# CITY OF PORTLAND BUILDING PERMIT

**PERMIT ID:** 2013-00813

has permission to **construct a family room addition 15' x 20' rear of home**

3 TYPICAL HEADER & EAVE DETAIL
 SCALE: 1 1/2"=1'-0"

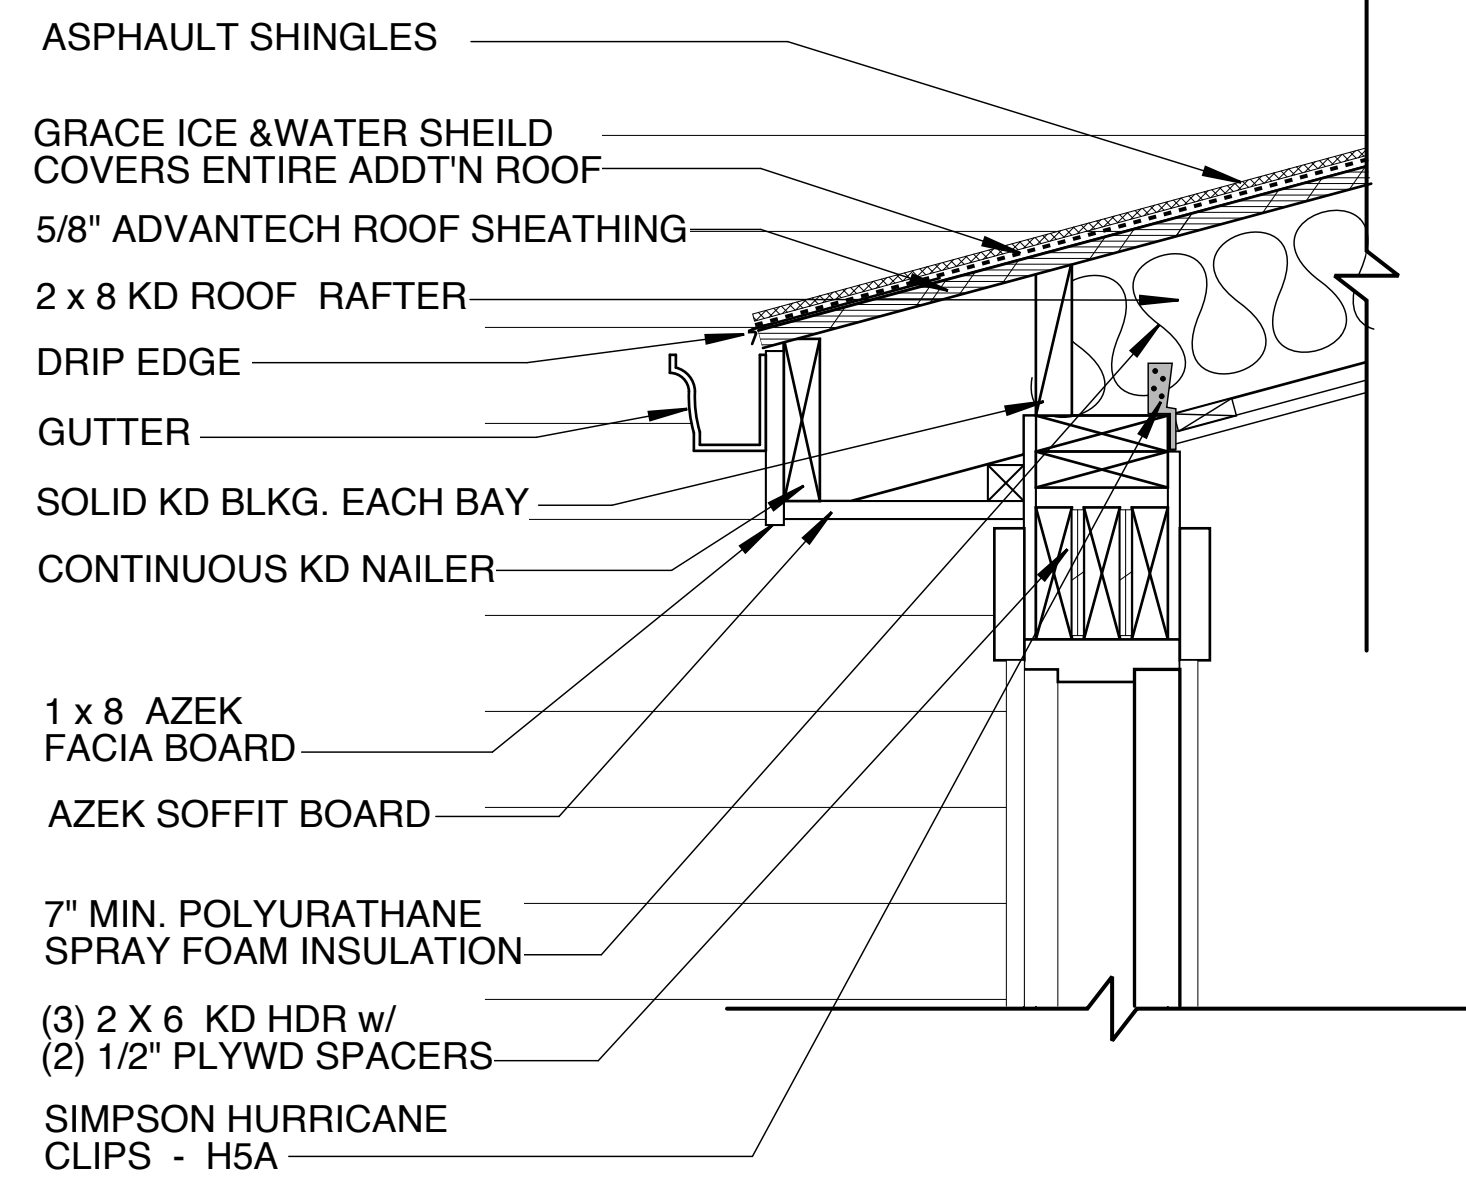
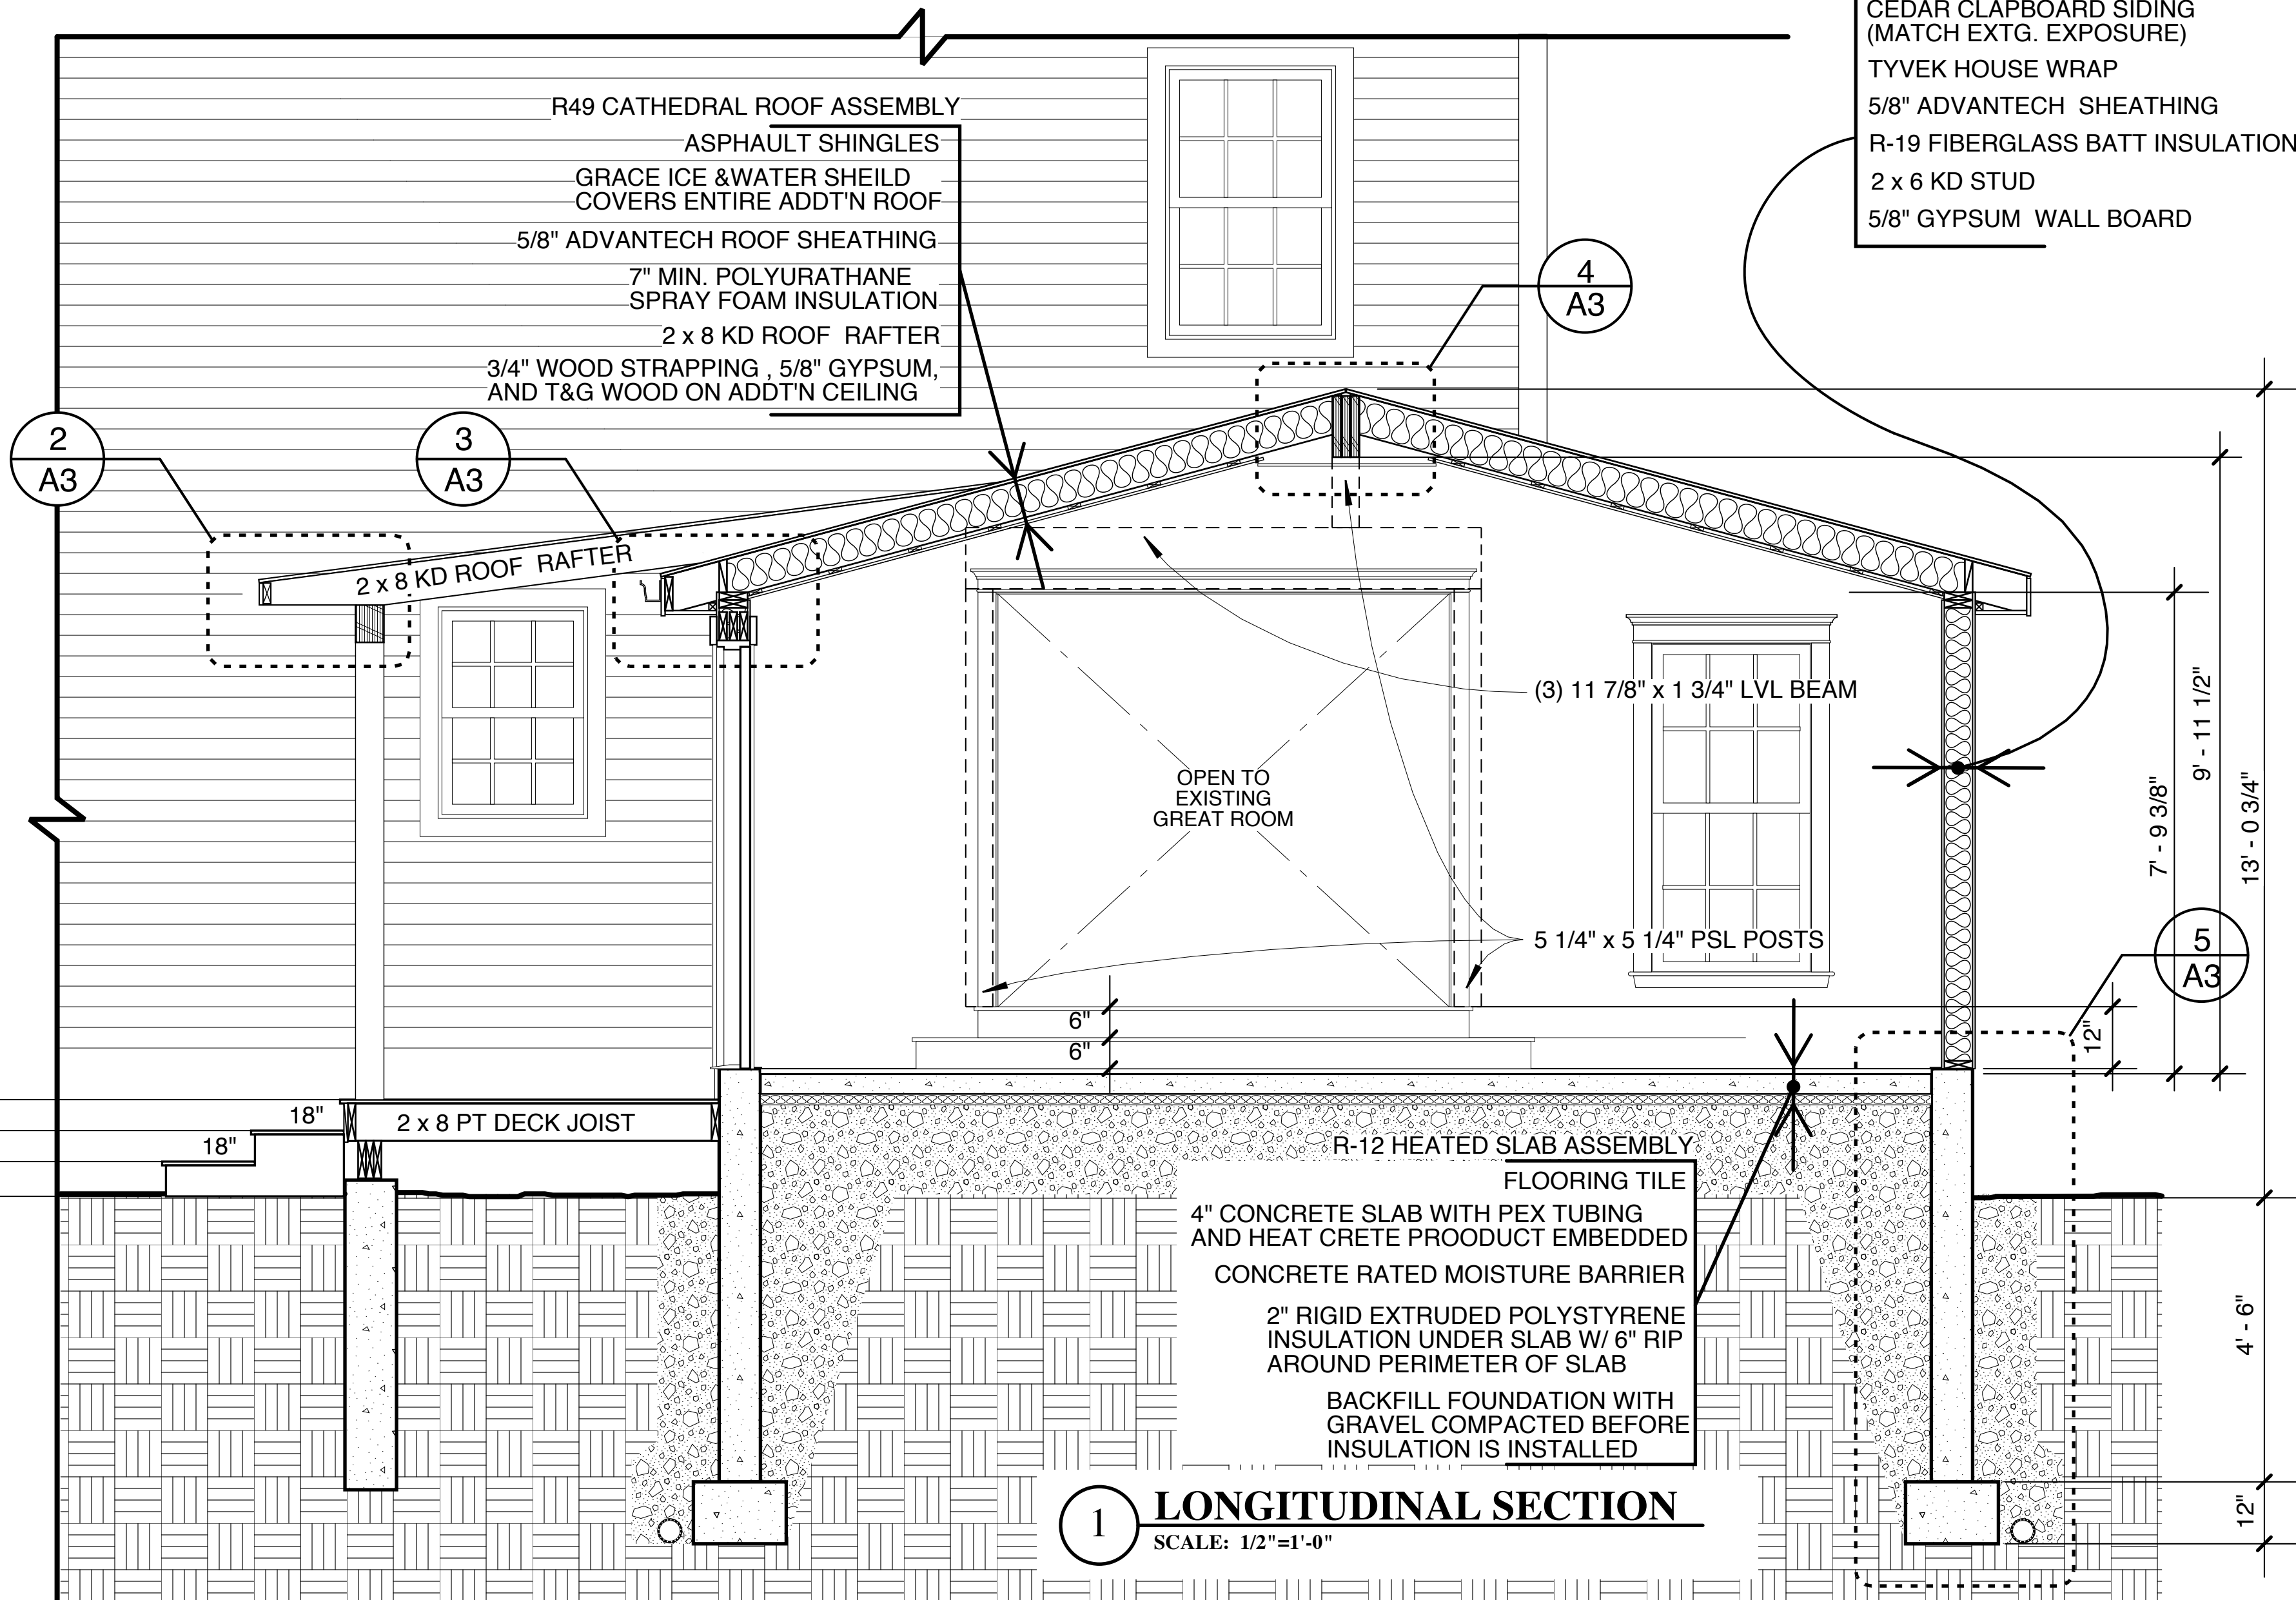
- 1) The header over the sliding door must be 2 - 2" x 8"-s minimum.
- 2) Separate permits are required for any electrical, plumbing, sprinkler, fire alarm, HVAC systems, heating appliances, including pellet/wood stoves, commercial hood exhaust systems and fuel tanks. Separate plans may need to be submitted for approval as a part of this process.
- 3) The design load spec sheets for any engineered beam(s) / Trusses must be submitted to this office.
- 4) Permit approved based upon information provided by the applicant or design professional. Any deviation from the final approved plans requires separate review and approval prior to work.
